From: Amanda Scholes on behalf of Planning.Responses
Sent: 16 March 2021 11:25
To: Planning Scanning
Subject: FW: Planning Consultation on: BR/8/21/RES

Engineers Comments Regarding Surface Water Drainage

Application No: BR/8/21/RES

Description of Works: Approval of reserved matters following BR/142/18/OUT for the demolition & conversion of existing public house with residential accommodation to 1st floor to form 10 No. residential flats over 3.5 storeys.

Drawing Title:
PROPOSED SITE PLAN

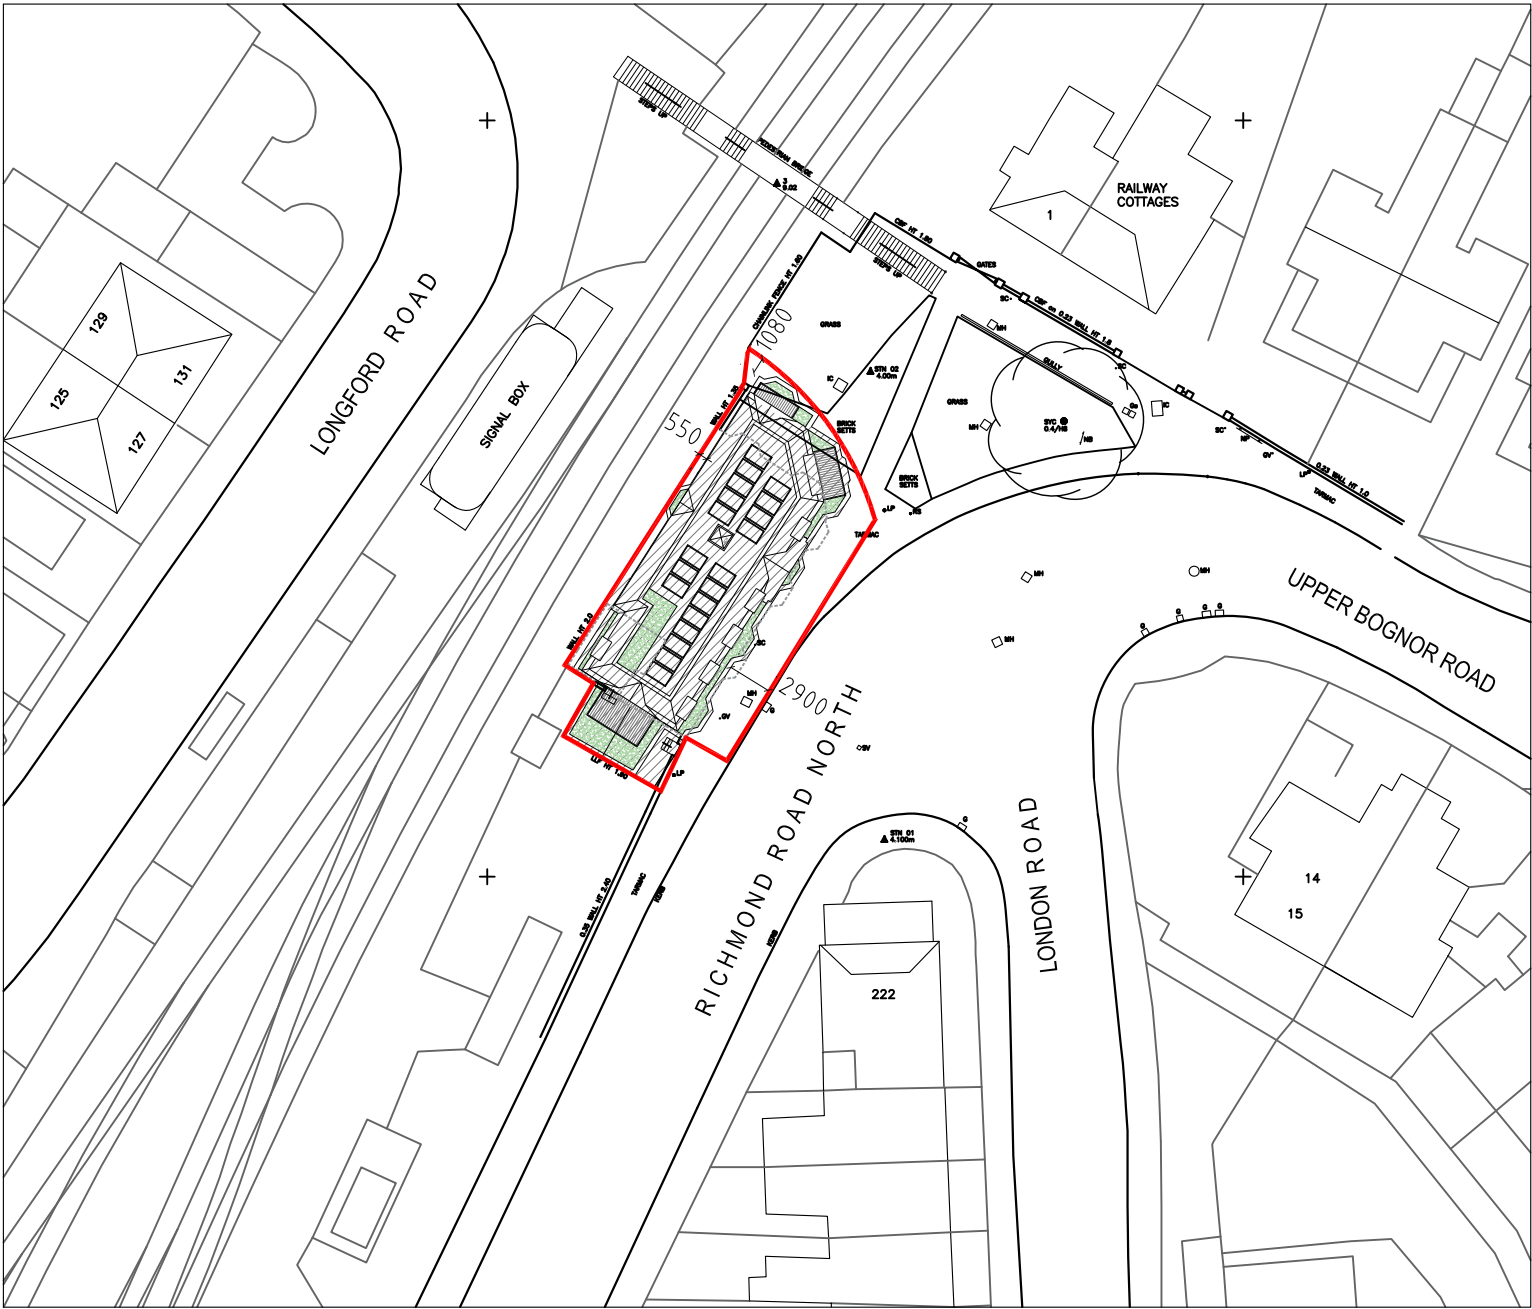
The applicant is reminded that the outline planning approval was conditioned relating to surface water drainage design. A requirement of that condition is winter groundwater monitoring and winter infiltration testing to inform the drainage design. No evidence of that monitoring/testing has been submitted at this stage. The foul water

drainage statement loosely refers to the possibility of an infiltration blanket or discharging surface water to the surface water sewer but no designs or calculations have been submitted.

We support the proposed disconnection of all surface water from the foul sewer, and will expect the hierarchy for sustainable drainage to be followed, therefore infiltration must be prioritised above discharging to the surface water sewer. However, it is unclear if there is enough space on the site to support infiltration features (5m from buildings and highway), usually having insufficient space would be an unacceptable excuse for not following the hierarchy, however, given that this is a replacement dwelling with an equitable impermeable area we would be willing to discuss the proposals to agree a suitable approach.
